CITY OF ALBUQUERQUE

**RE: Perez Collision Center
Grading and Drainage Plan
Engineer's Stamp Date 7-28-16 (File: H14D039)**

Based upon the information provided in your submittal received 8-2-2016, the above-referenced plan is approved for Building Permit and SO-19 Permit with the following conditions:

GRADING AND DRAINAGE PLAN

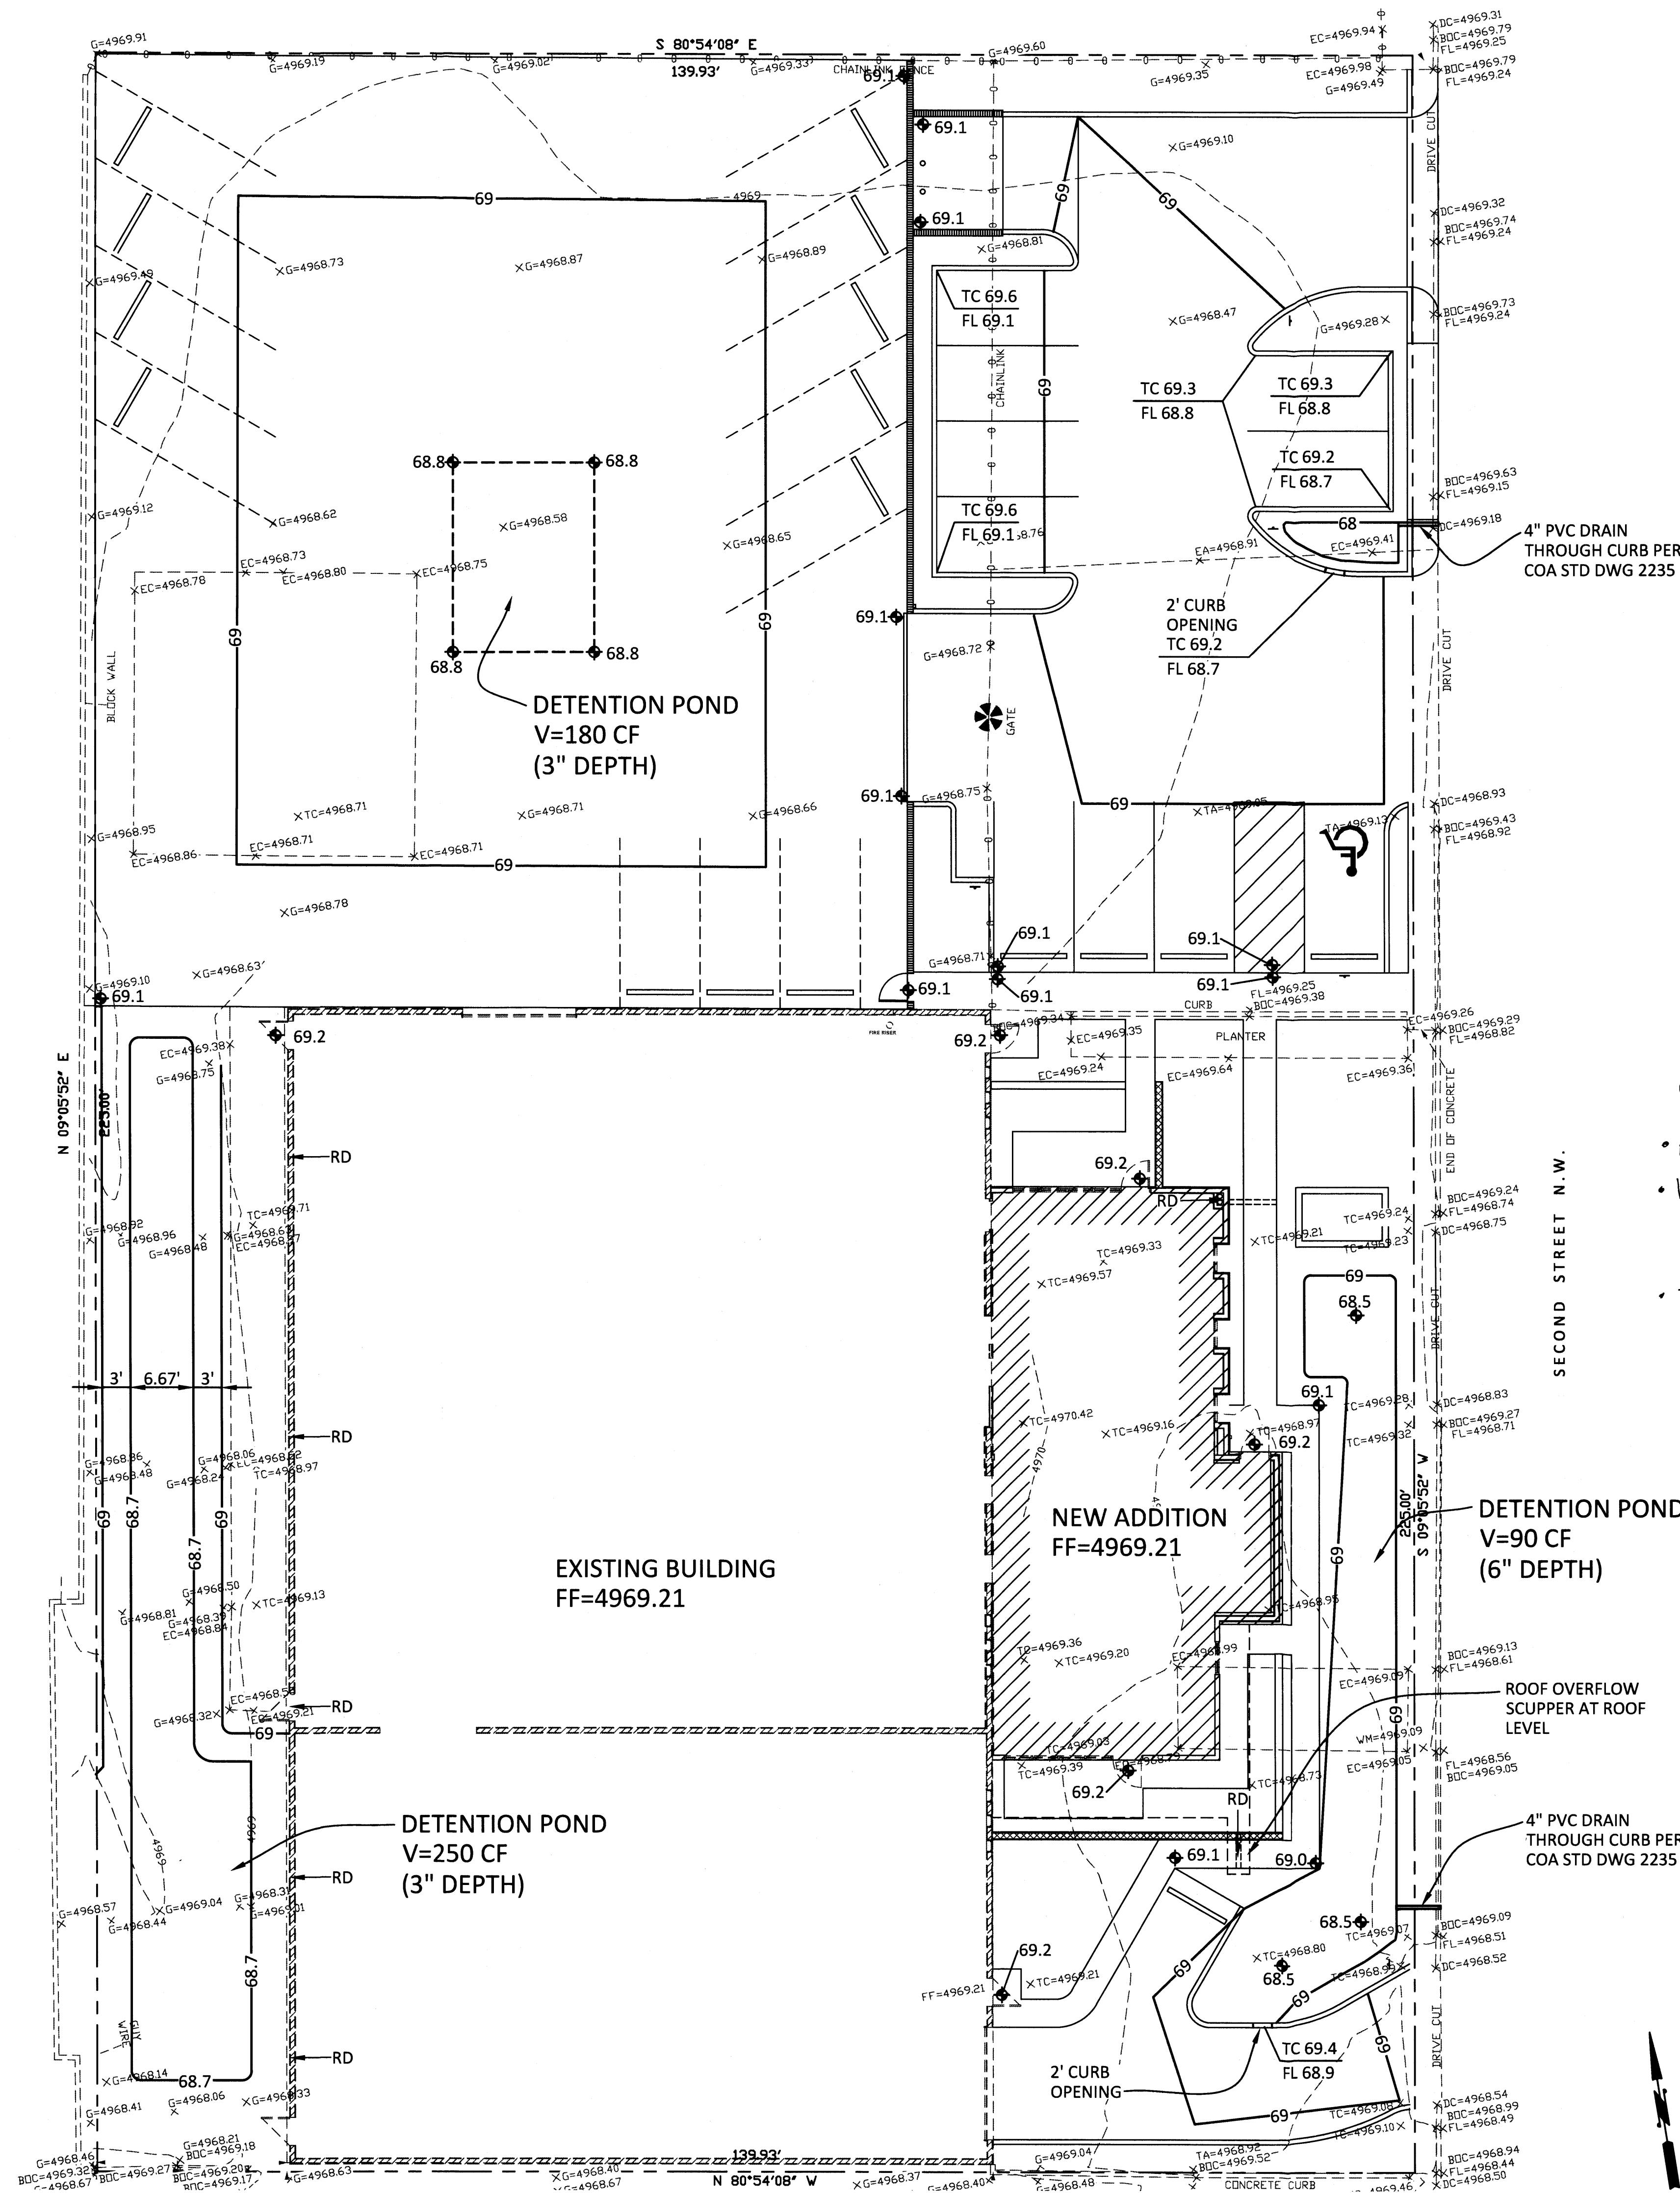
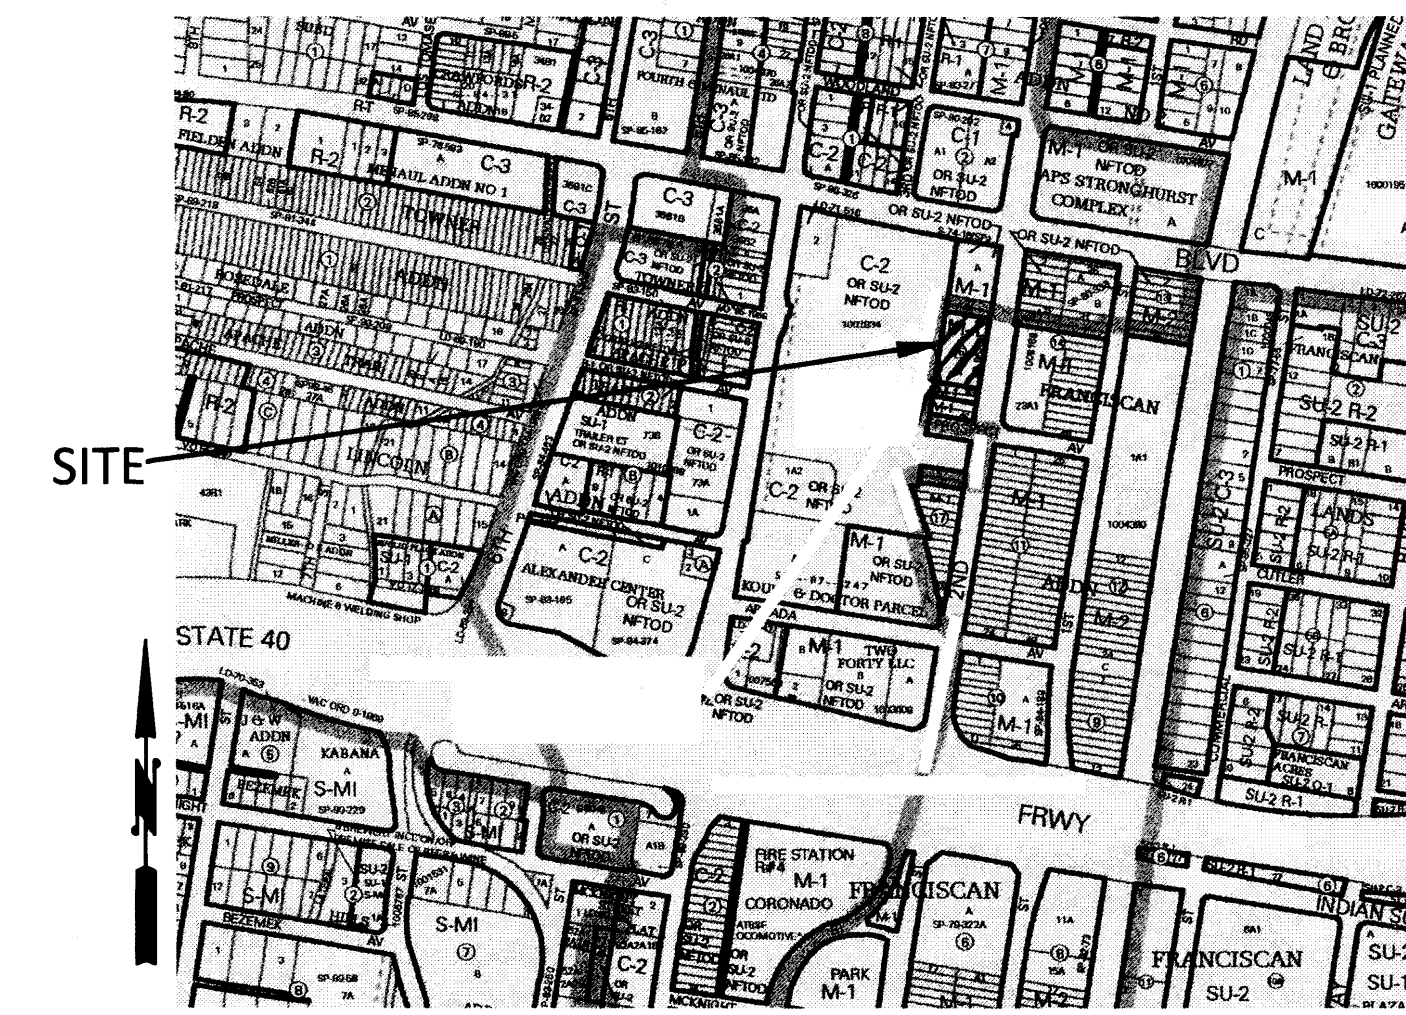
1. The 4" PVC drains across the sidewalk need to be completed through an SO-19 Permit. Attached are the Standard SO-19 Notes, please ensure that they are forwarded to the Contractor prior to Construction. Work in the Right of Way needs to be pre-authorized and accepted by the City. Removals of sidewalk will need to be made at the nearest joint.
2. Provide first flush calculations (required vs provided).
3. Label the areas that will be gravel surfaced and asphalt surfaced.
